COLORADO
Department of Transportation

December 22, 2020

RE: Helton Amended Site Plan - South Academy Business Park_ SH85.87

SOUTH ACADEMY BUSINESS CENTER 4425 HWY 85-87 EL PASO COUNTY, COLORADO SITE DEVELOPMENT PLAN

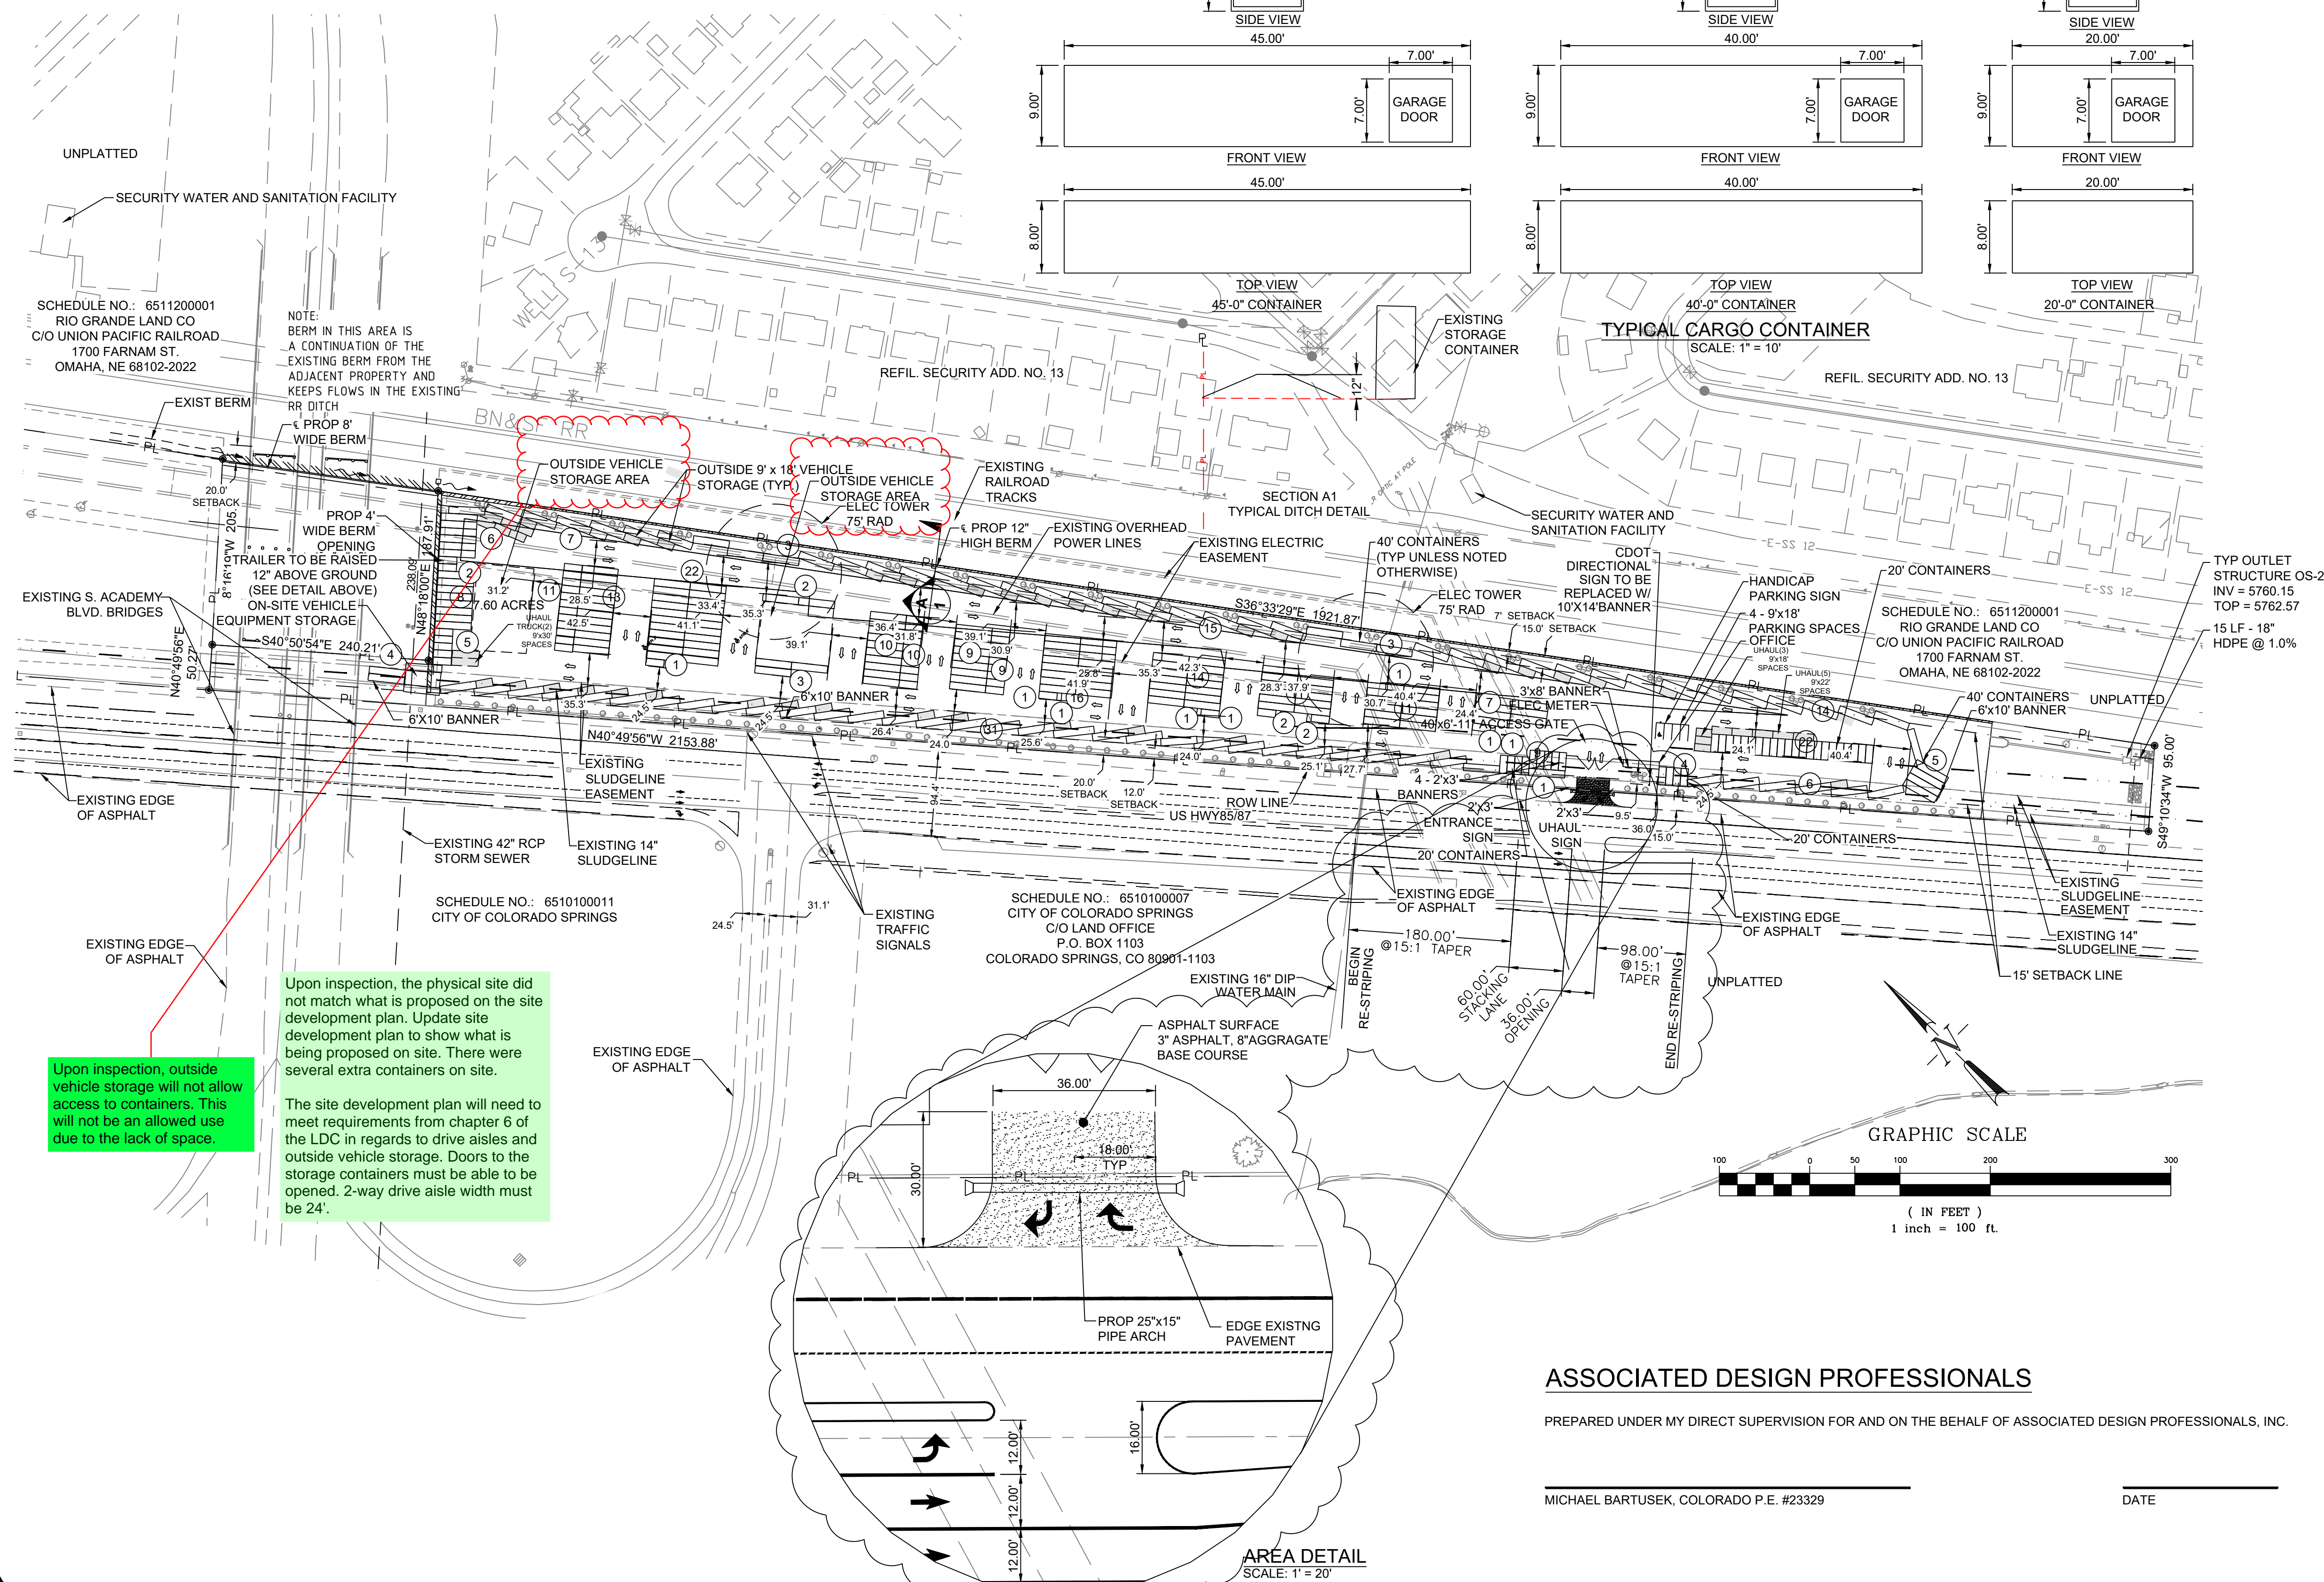
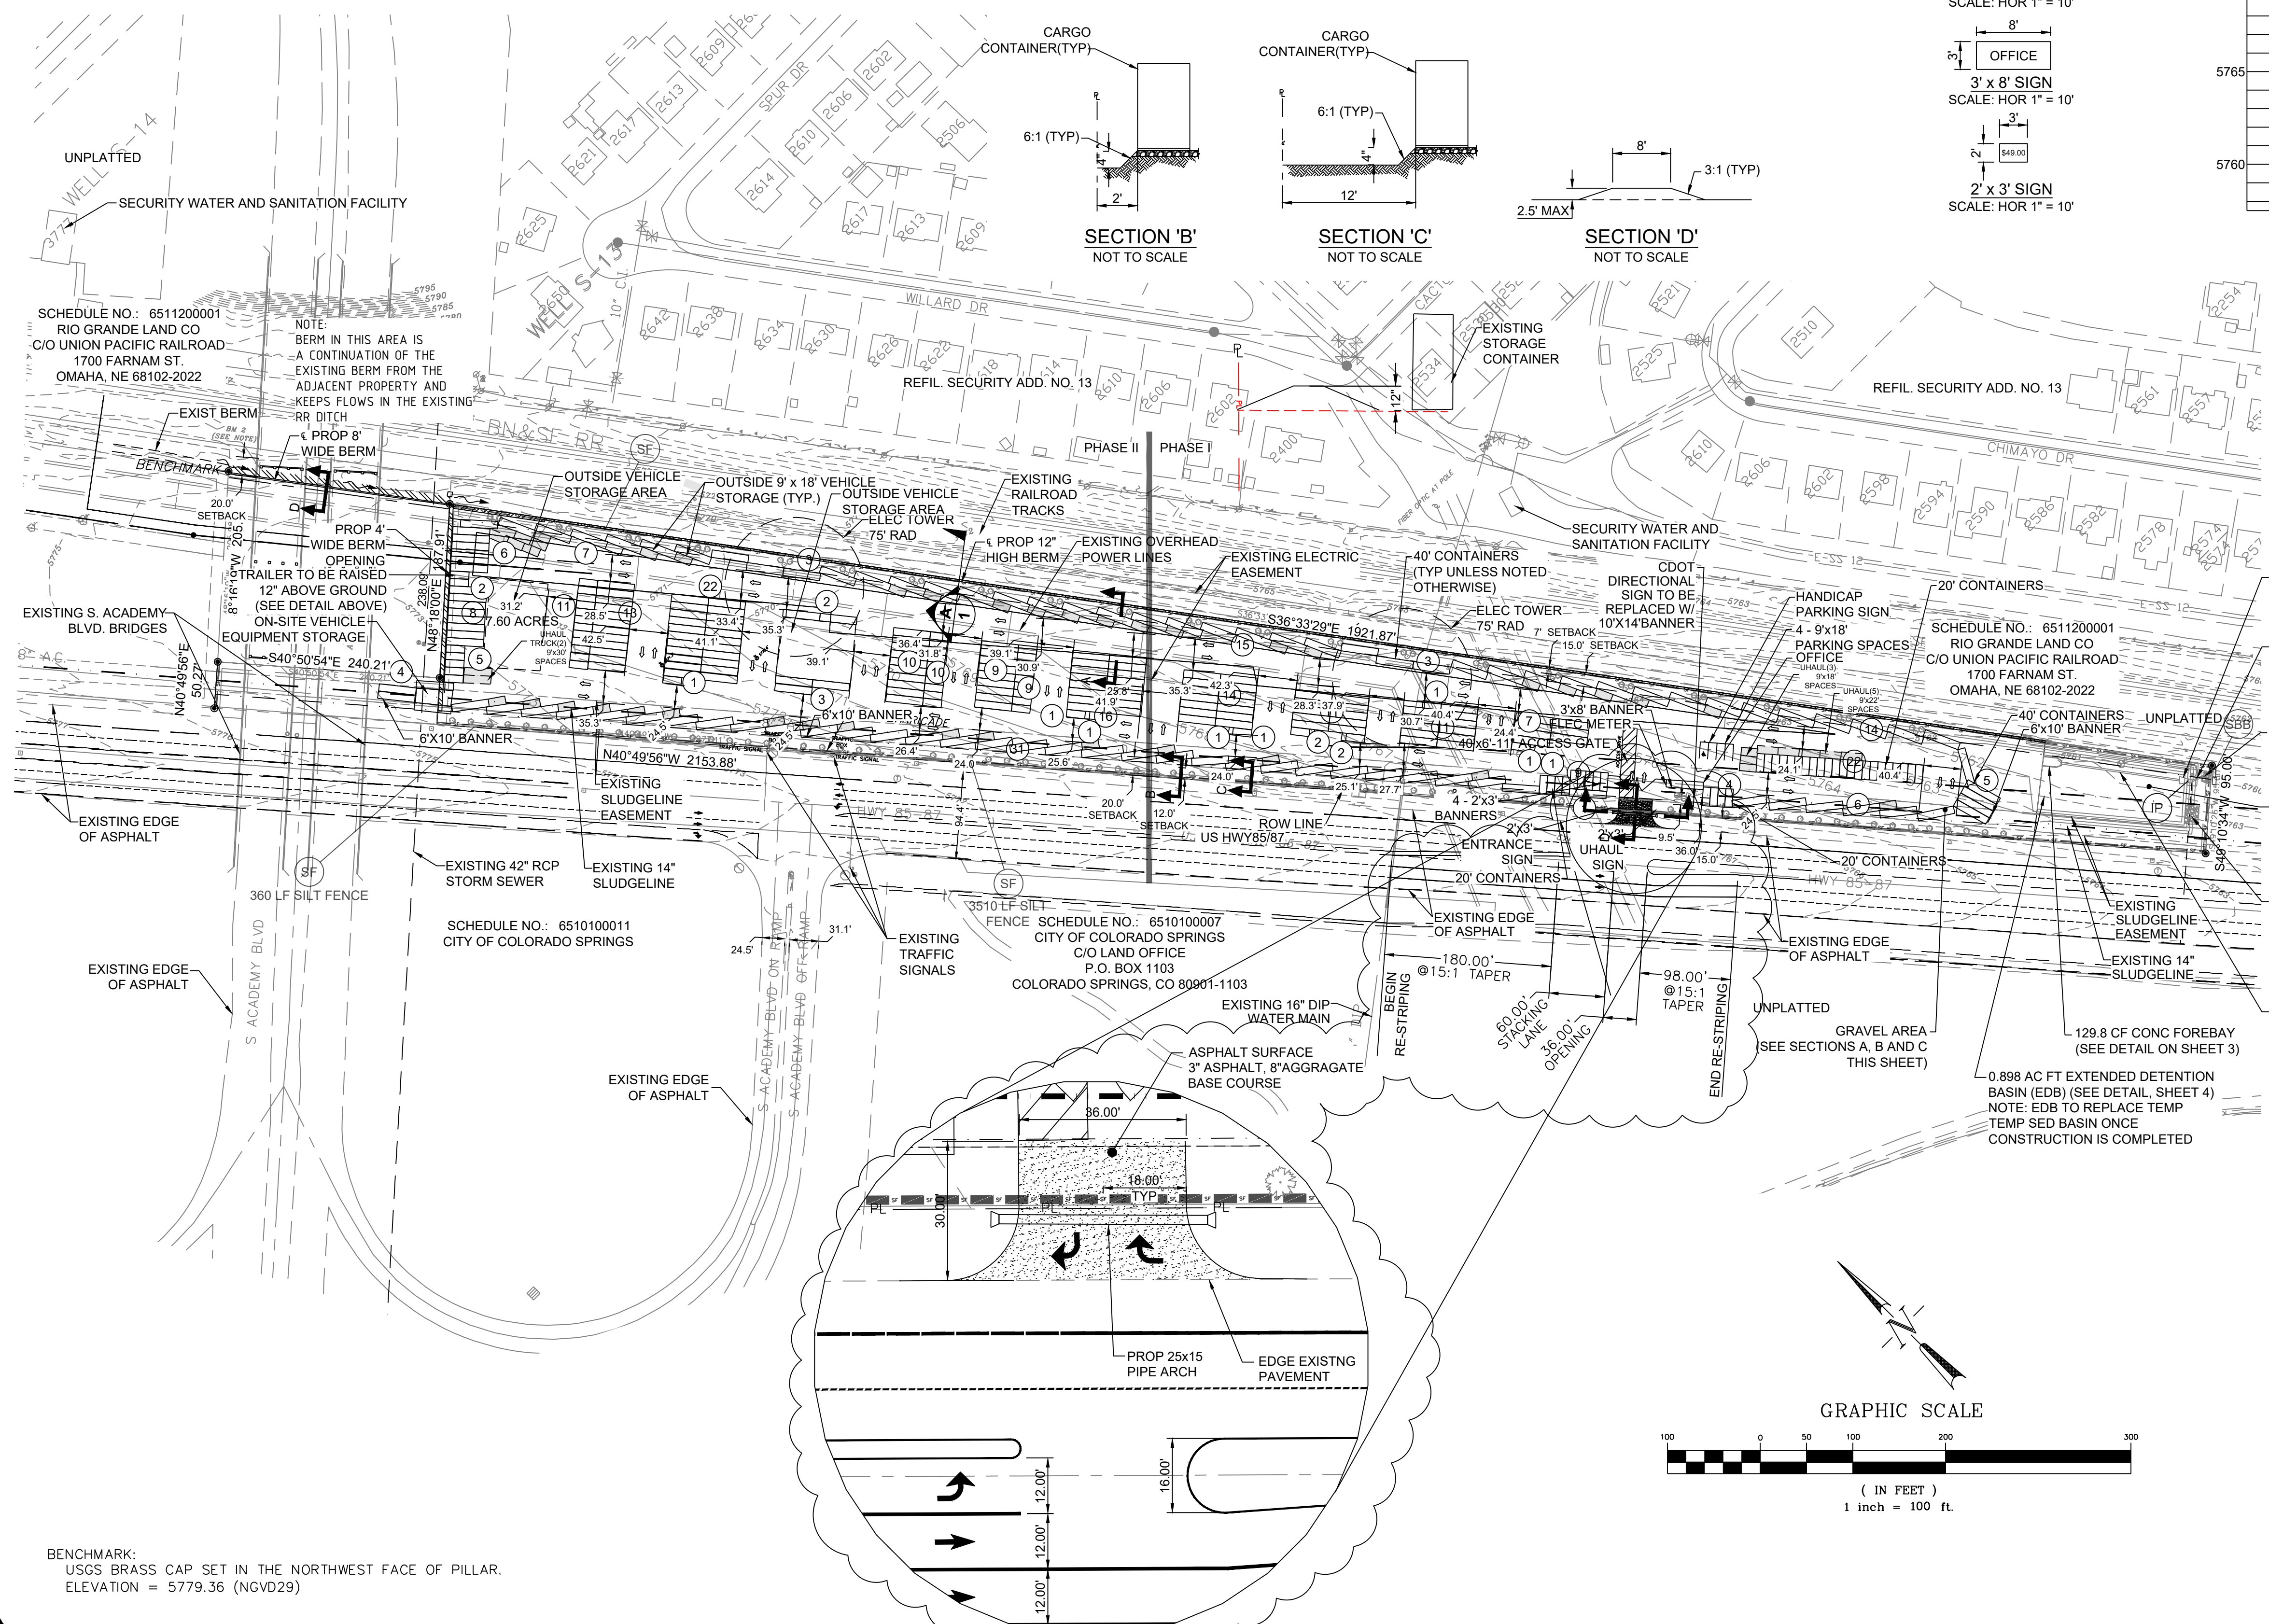
- CDOT Access Dept. comments are as follows:
 - a. The developer is required to apply for a new Colorado Department of Transportation Access Permit to document the new roadway improvements proposed.
 - b. No additional access from SH85/87 will be permitted to the site.
 - c. Review of the acces permit 218005 from CDOT mentions that Right In/Right Out traffic movements are the only allowable traffic movements until such a time of expansion which requires a new access permit, roadway improvements to SH85/87 and a centerline non-traversable median.
